Our ref: Waste Management Facility, Botany (SSD-62855708)

Subject: Request for Additional Information

I refer to the Submissions Report for the Waste Management Facility, Botany, State significant development (SSD) application (SSD-62855708). The Department of Planning, Housing and Infrastructure (Department) is reviewing the Submissions Report in consultation with relevant government stakeholders, including Bayside Council (Council). Advice received from government authorities has been forwarded to you for consideration and response.

The Department has reviewed the Submissions Report and requests the following matters regarding the assessment of traffic impacts be addressed as part of a consolidated response to the matters raised by the government authorities. These comments relate to the Traffic Impact Assessment prepared by Traffix dated 20 March 2025, Version 14, submitted as Appendix C to the Submissions Report.

Project No.	Drawing Phase	Drawing No.	Rev.
23.464	RFI	TX.06	A

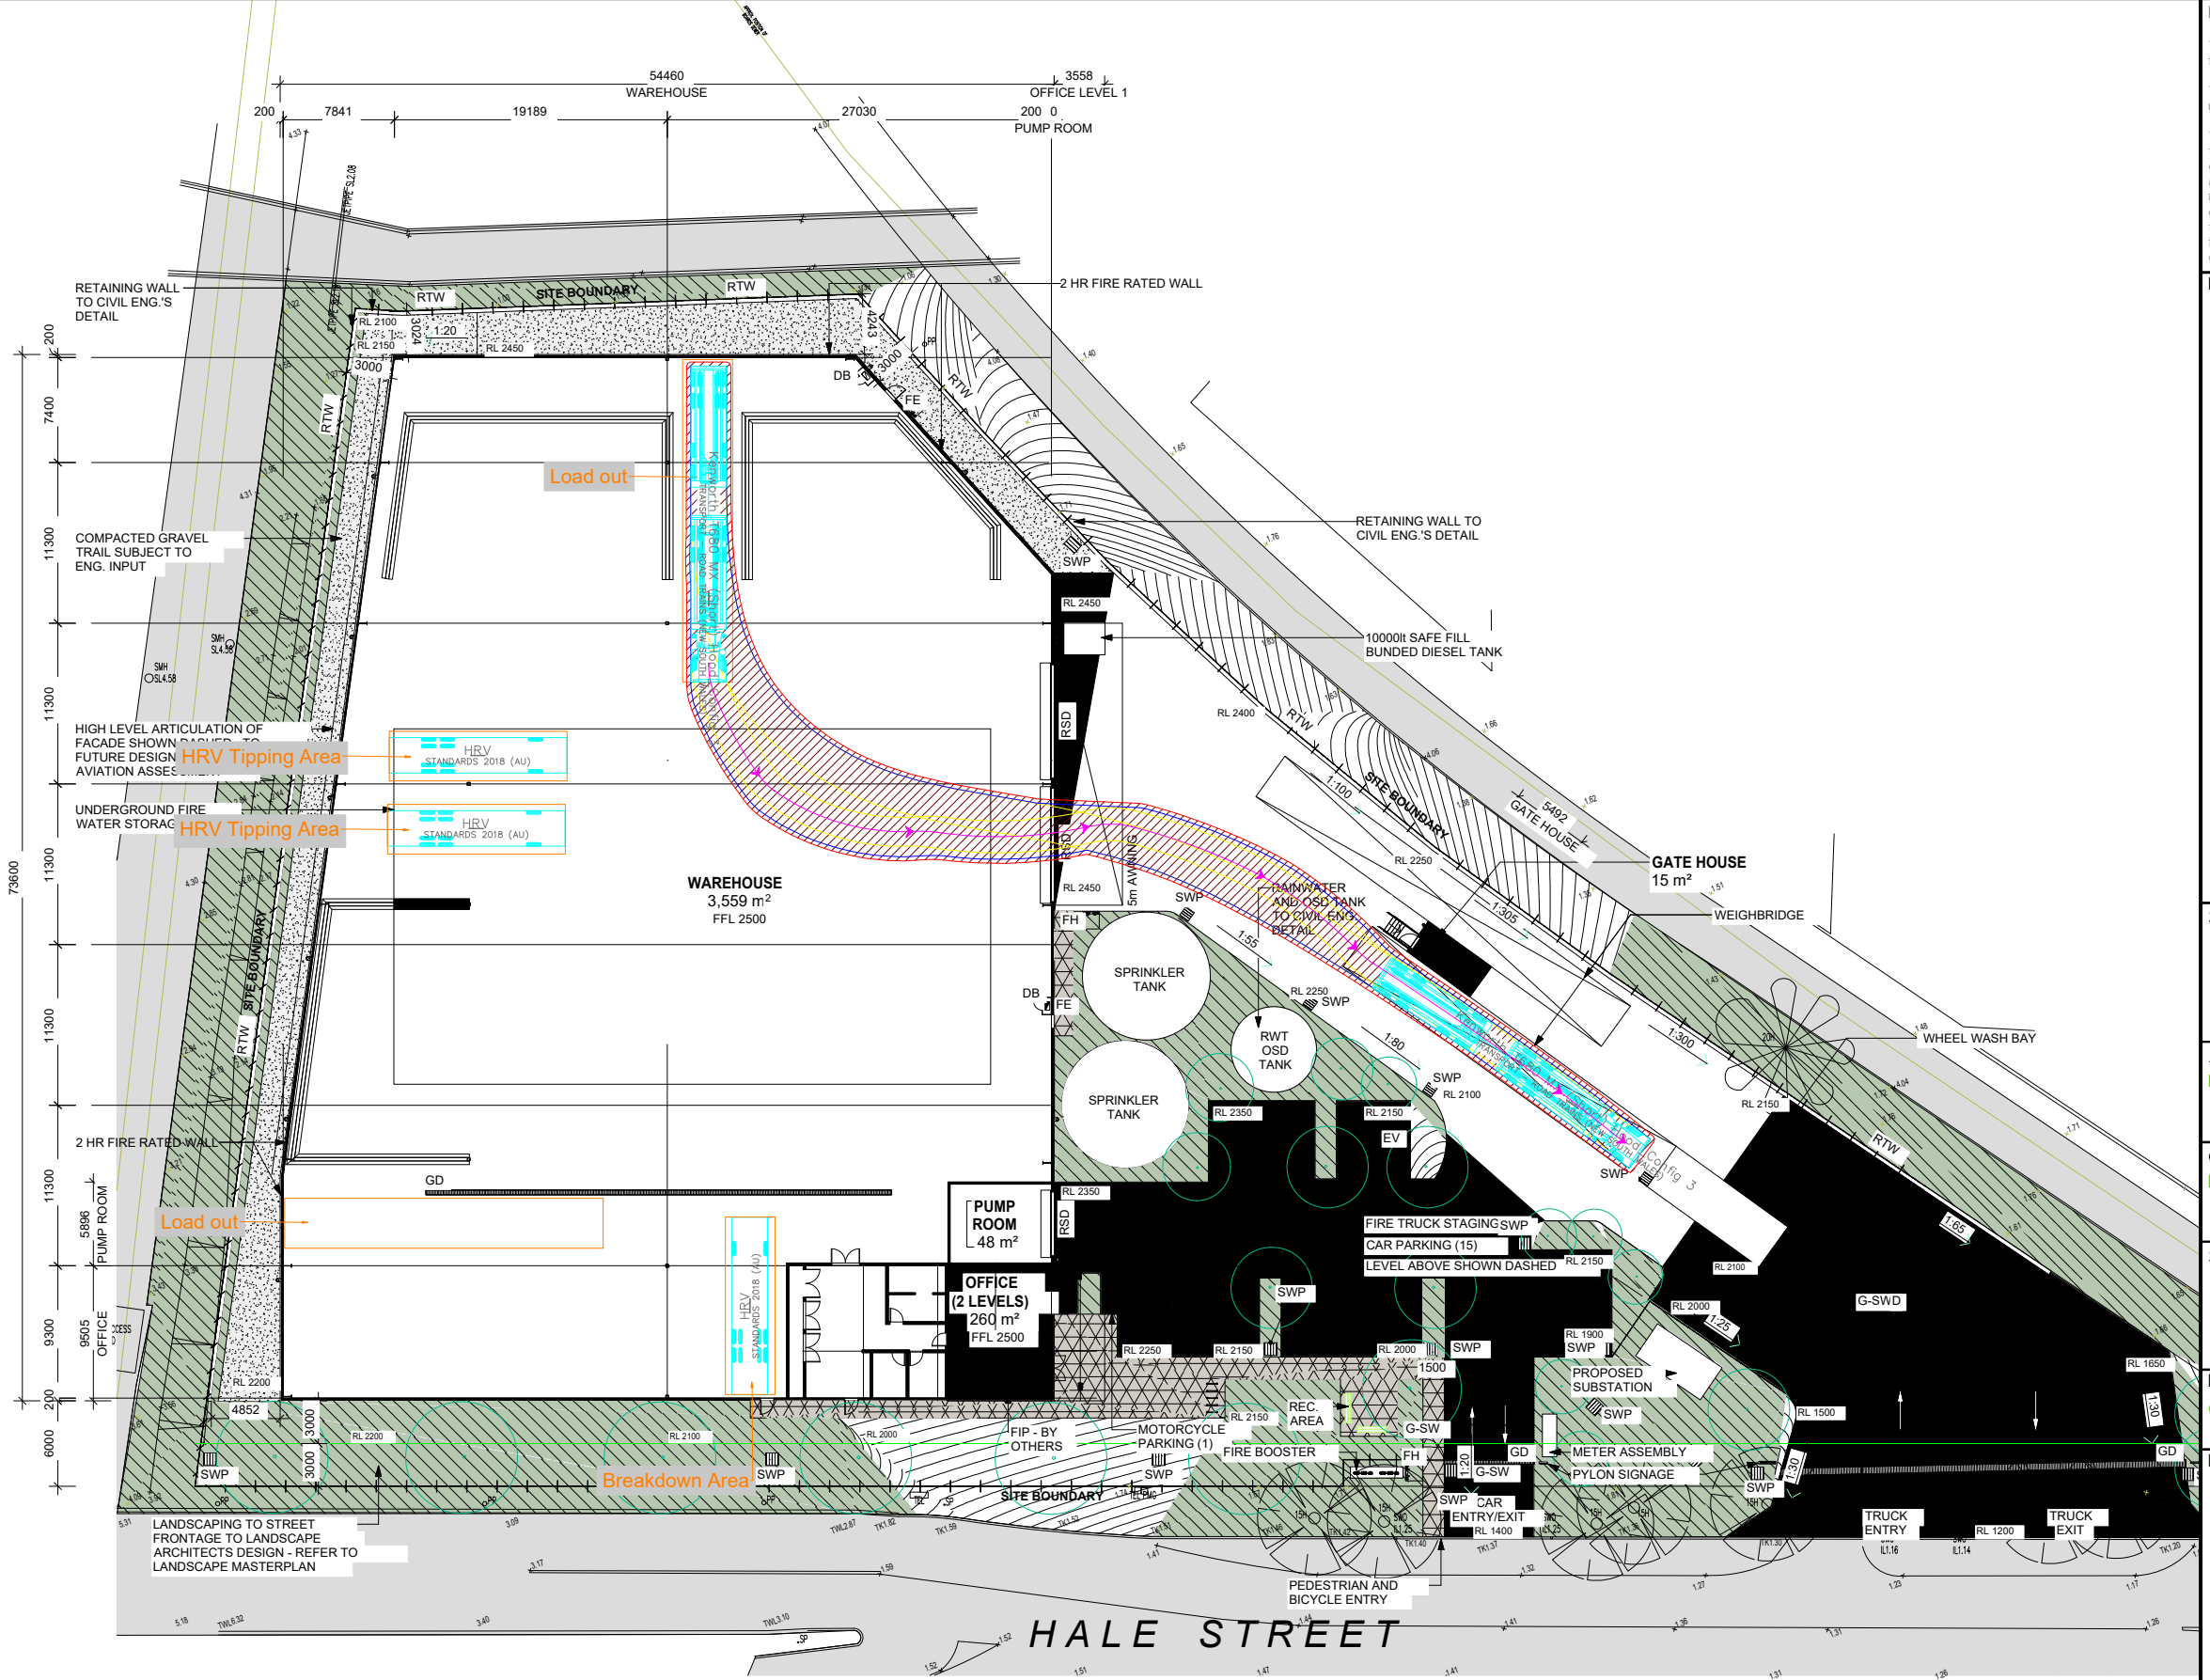
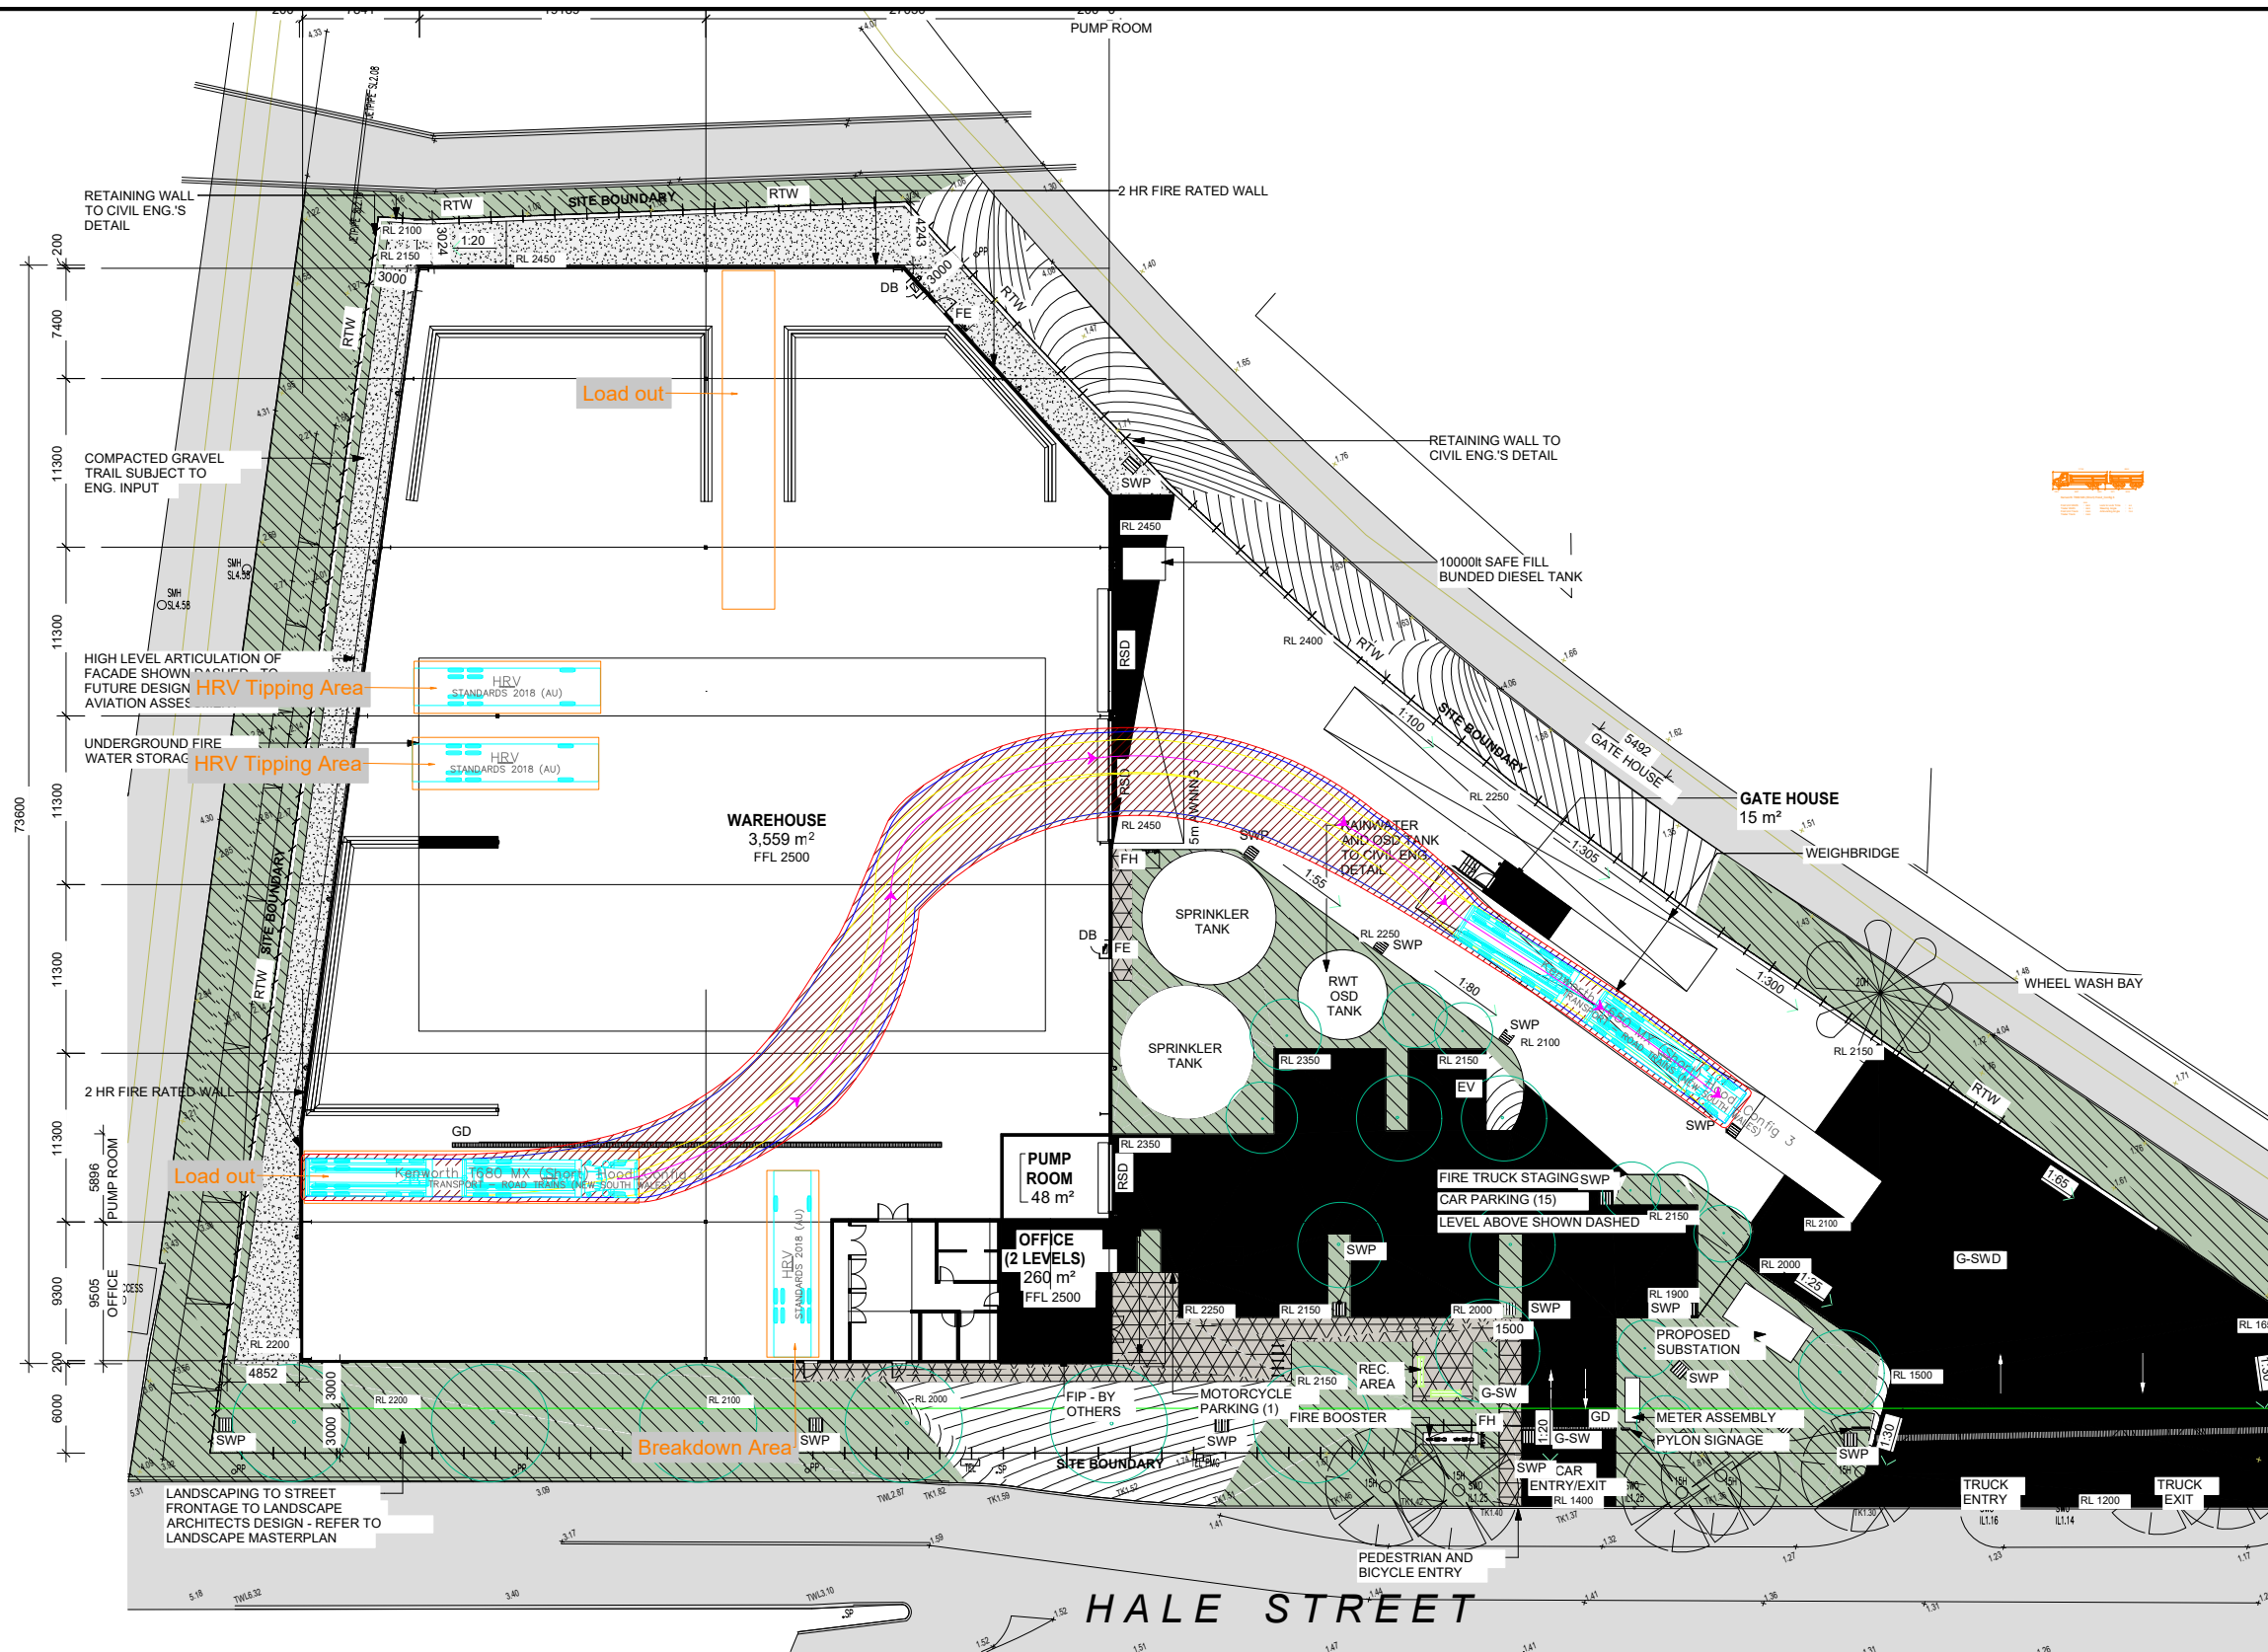
- The swept path analysis shows the movement of a B-double exiting the site on a separate drawing to the swept path of a B-double accessing the site. It is not possible to determine if there will be any conflicts if these two movements occur simultaneously. Please provide a plan that shows a B-double entering and exiting the site simultaneously demonstrating that this movement can occur safely and without any conflict to either vehicle or on-street parking, and without crossing the centreline of Hale Street.
